Notice of Exhibition of application for Parramatta Light Rail Stage 2 (SSI-10035)

As delegate of the Heritage Council of NSW, I provide the following comments:

Figure 12.8 Historical Archaeological Management Units with medium to high potential (Melrose Park)

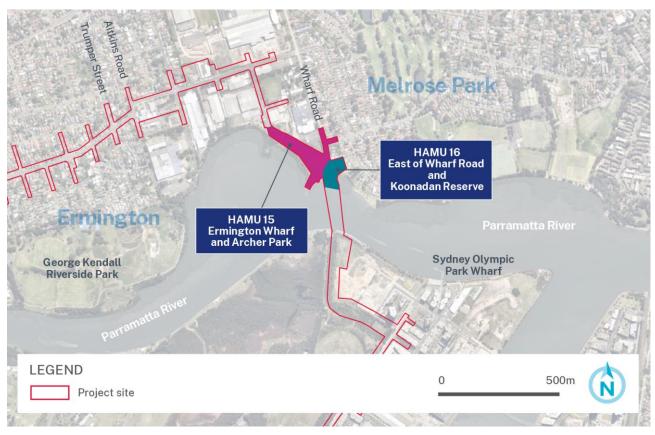
6. Given that the potential for a State significant archaeological resource is considered at least medium at the five identified HAMUs, the applicant is encouraged to start the preparation of a risk matrix now, to assist with planning for the management these potential finds. In particular the applicant should consider how any such finds may affect the project timeline and budget through potential design modifications or salvage requirements. By considering the risks associated with these potential finds now, possible future timeframe and budget pressures can be alleviated by factoring them into project planning and pipeline design.
